OUT18/1615

**WestConnex M4-M5 Link
Submissions and Preferred Infrastructure Report and draft conditions**

WestConnex M4-M5 Link
Submissions and Preferred Infrastructure Report and draft conditions
Detailed comments

Figure 10 Geological long-section - M4 East to Anzac Bridge - Section 3

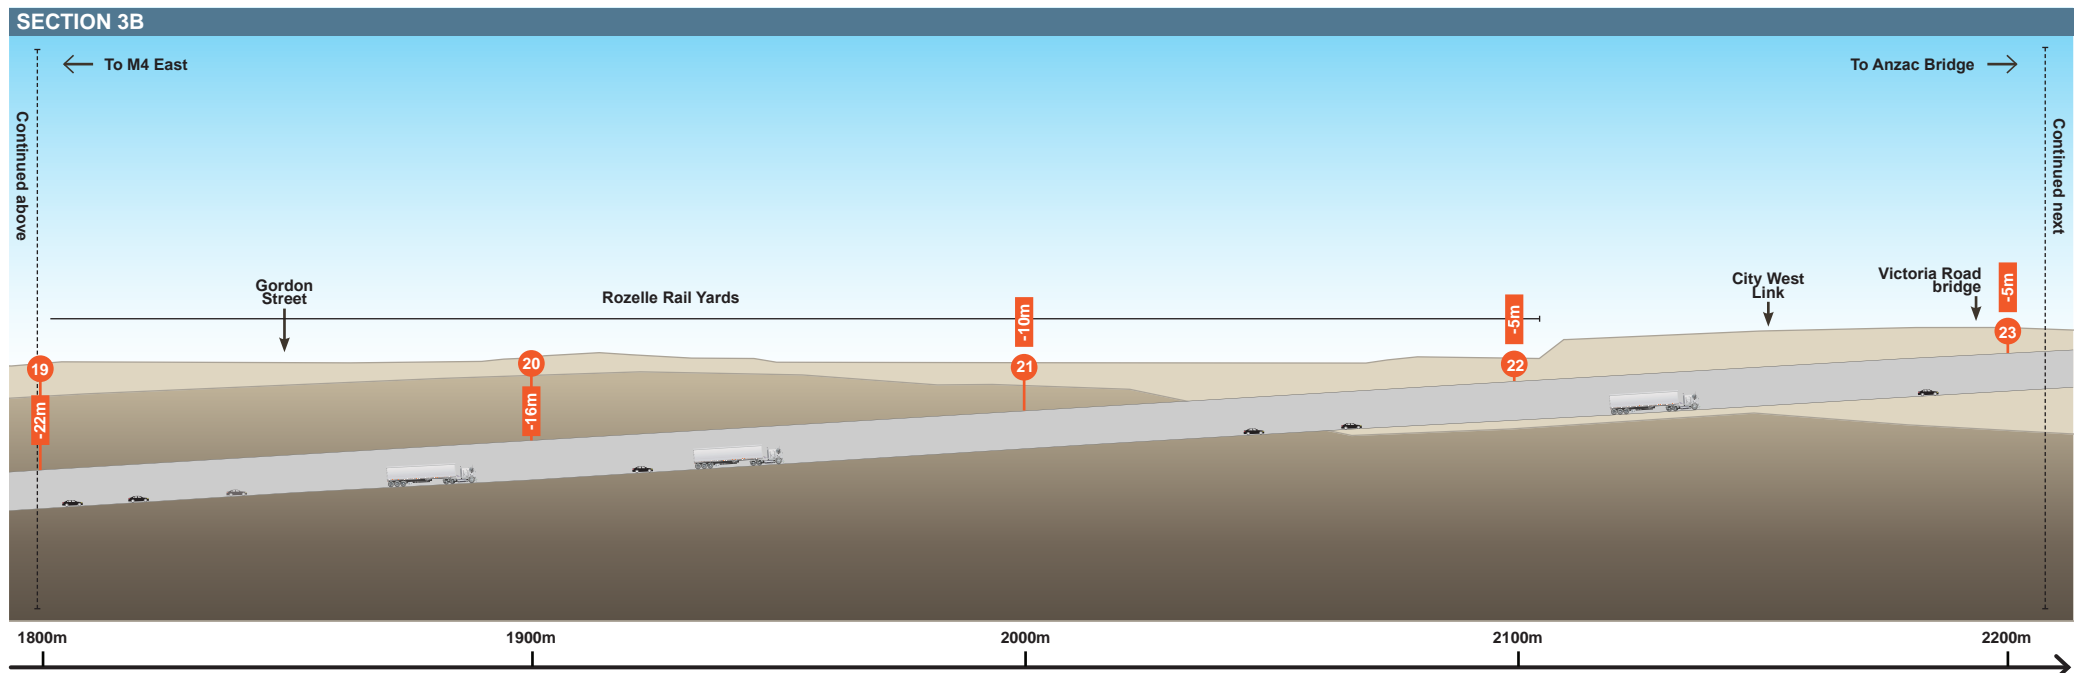
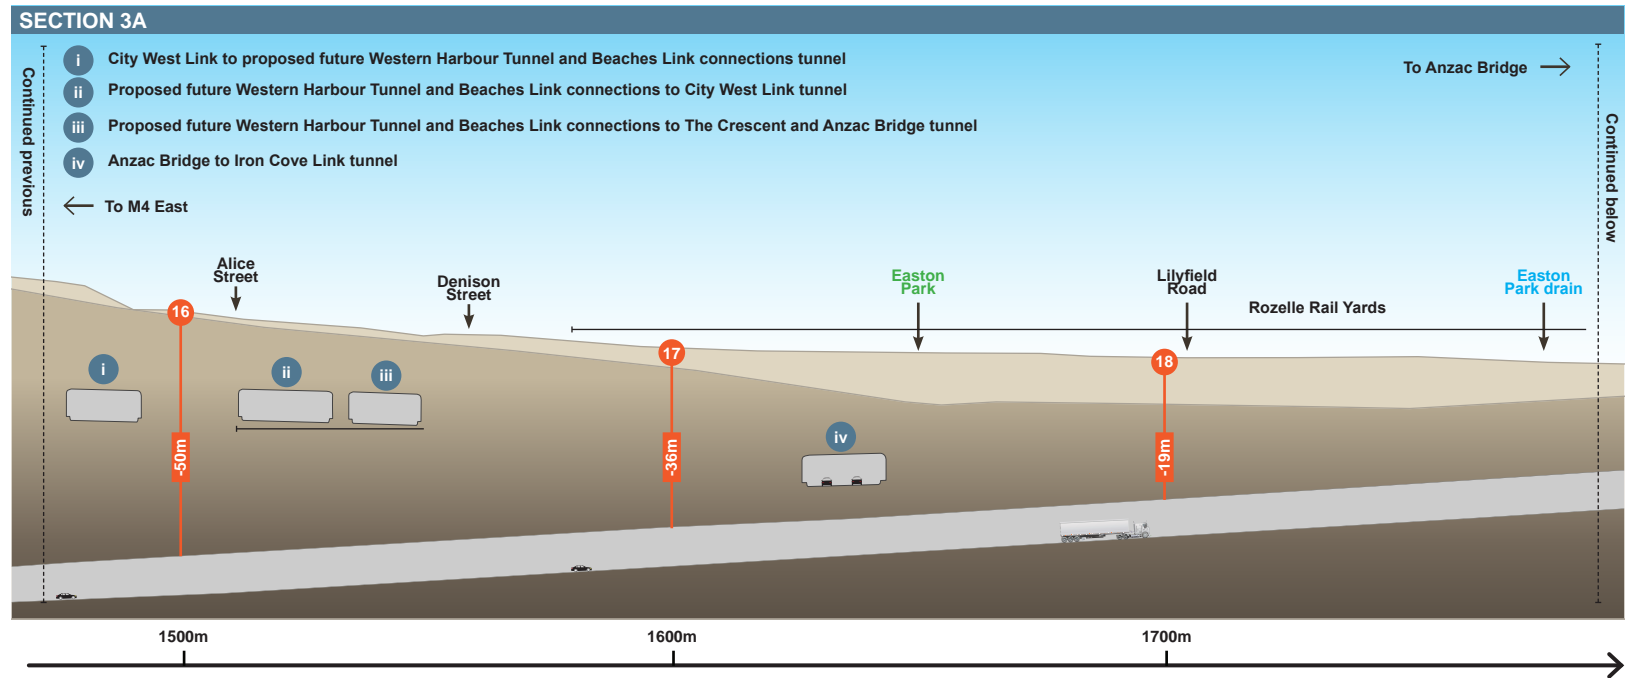
DoI Water has concerns regarding the un-tanked tunnel sections where there will be remaining thin (<10 m) sandstone roof cover through which draining of the alluvium may occur via fractures. The concern is that alluvium/palaeochannels will be drained in perpetuity.

The Department has particular concerns about the un-tanked sections of tunnel where the sandstone/shales are less than 10 m thick shown in the following:

- Figure 8. Selected geological long section M4 East to Anzac Bridge Sections 3b (from Appendix E (Volume 2B)), below the Rozelle Railyards,
- Figure 8. Selected geological long section Iron Cove Link to Anzac Bridge section 2 from Appendix E (Volume 2B) below the Rozelle railyards the overlying sandstone thins in and out and appears to thin down to as little as a few meters above the roof of the tunnel

- 1 Prior to tunnel construction the proponent must ascertain the tunnel sections where the degree of connectivity between the overlying roof sandstone/shale and alluvial/palaeochannel deposits is high, i.e. greater than 1 L/second/km. This will require a hydrogeological investigation to determine the connectivity between the alluvium and porous rock aquifer. This should include field based aquifer testing including pump testing.

Figure 6-19 Forward tracking from tidal areas showing particle travel time in years

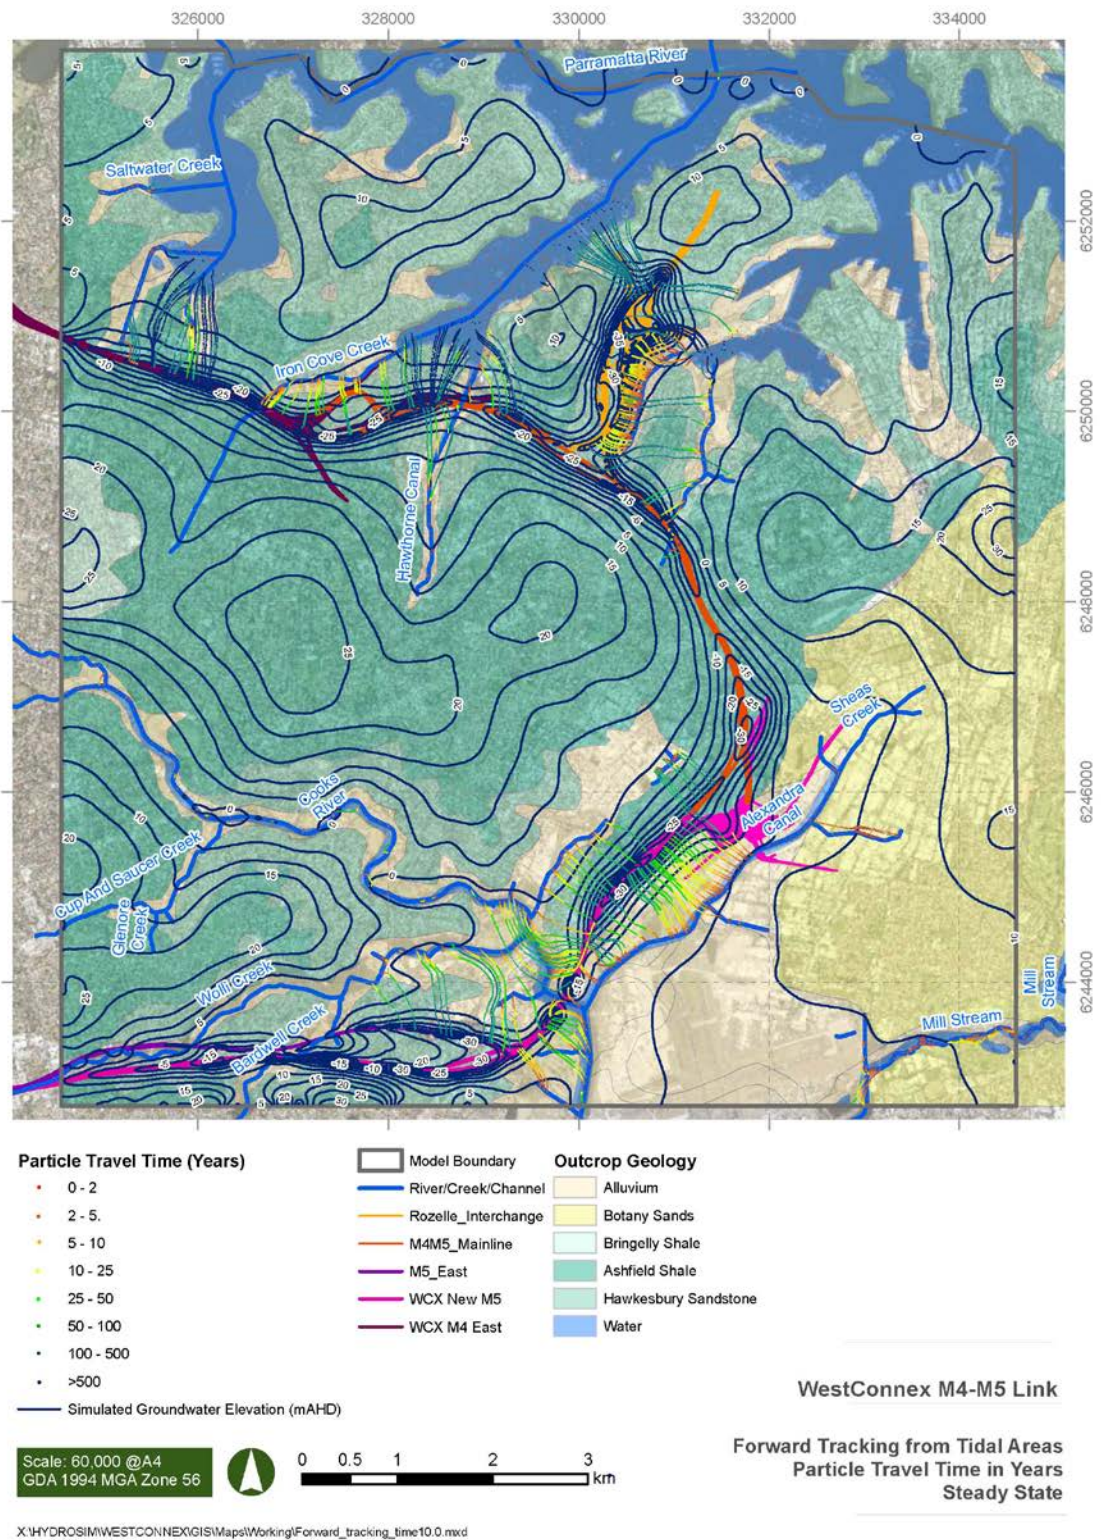
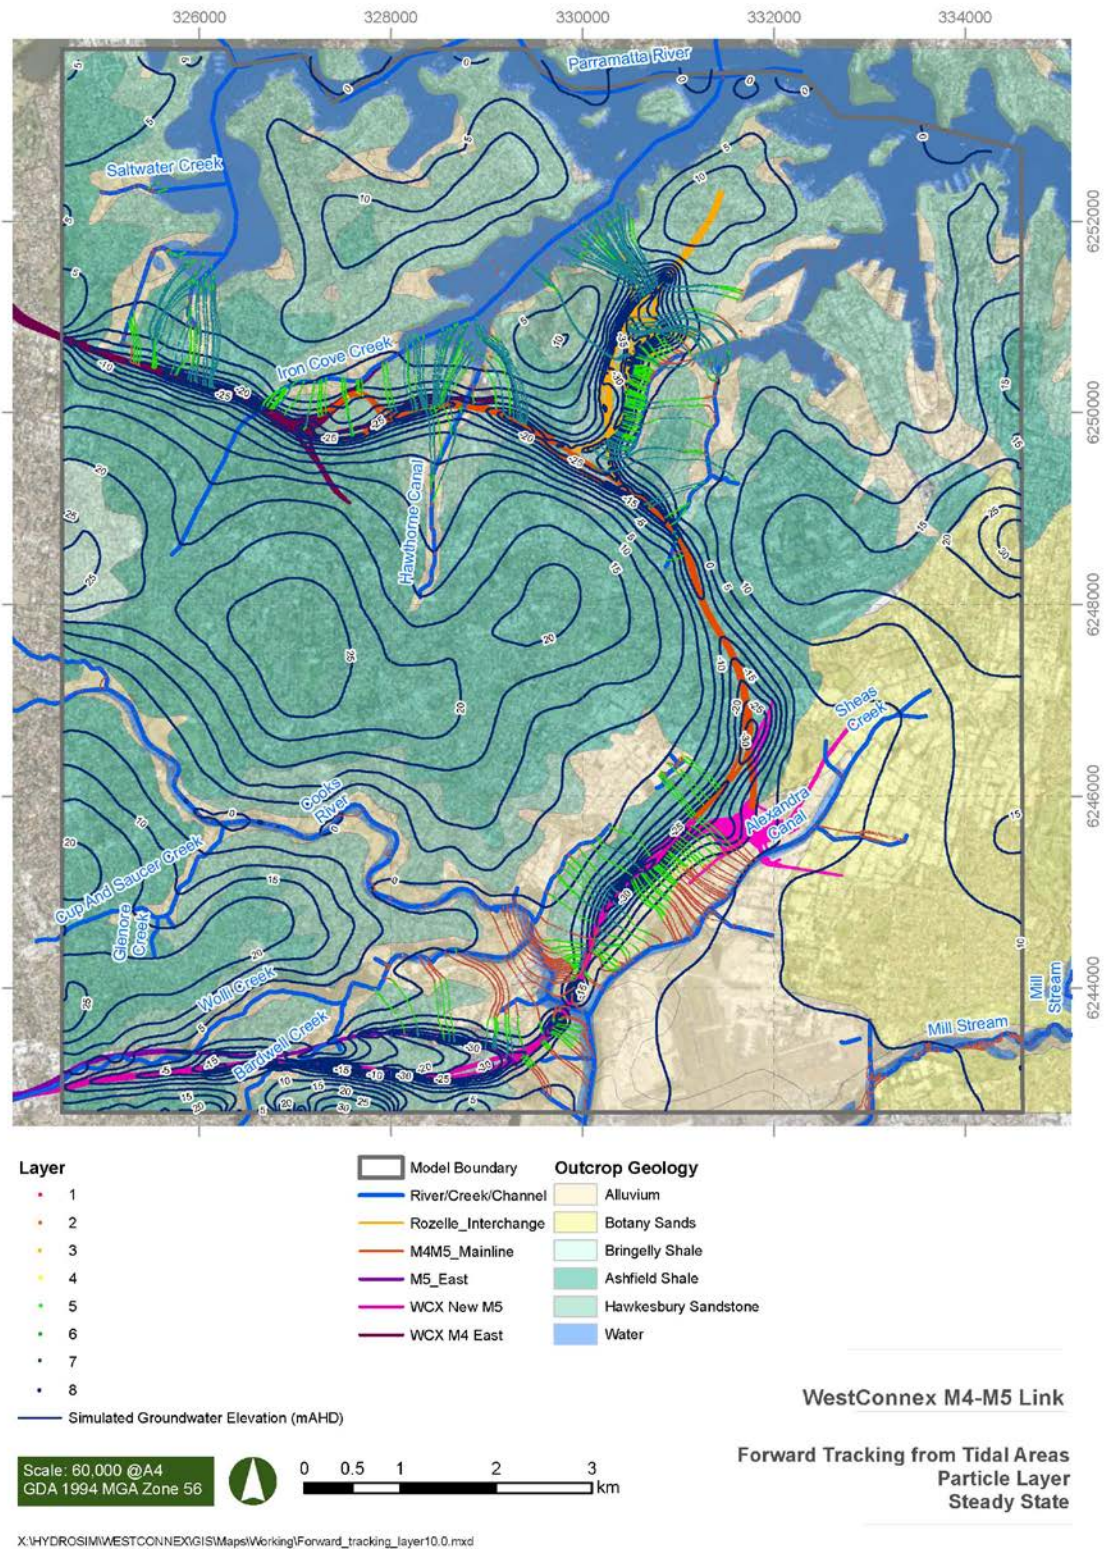
The proponent has demonstrated where salt water intrusion from tidal areas will occur in the Response to Submissions. Similarly the proponent has demonstrated that there will be no impact on Groundwater Dependent Ecosystems and other sensitive users. However this map indicates that the saltwater ingress is predicted to occur at distances greater than 40 m from the alignment with respect to the Aquifer Interference Policy.

The proponent has not sufficiently demonstrated that the saltwater ingress will have no long term impacts on future users of the groundwater resource should the tunnels result in long term dewatering of the surrounding aquifers with a resultant further ingress of the saline wedge.

The potential salinity issues apply to small areas of the project alignment at tunnel approaches to estuary - near salt water sources. Increased monitoring in this area will be required during construction and post construction so real time changes in groundwater quality can be monitored accurately and managed accordingly during both construction and post construction.

- 2 The proponent should include installation of sentinel monitoring bores pairs within the monitoring program to monitor the saline groundwater wedge between the estuarine areas and the tunnel.
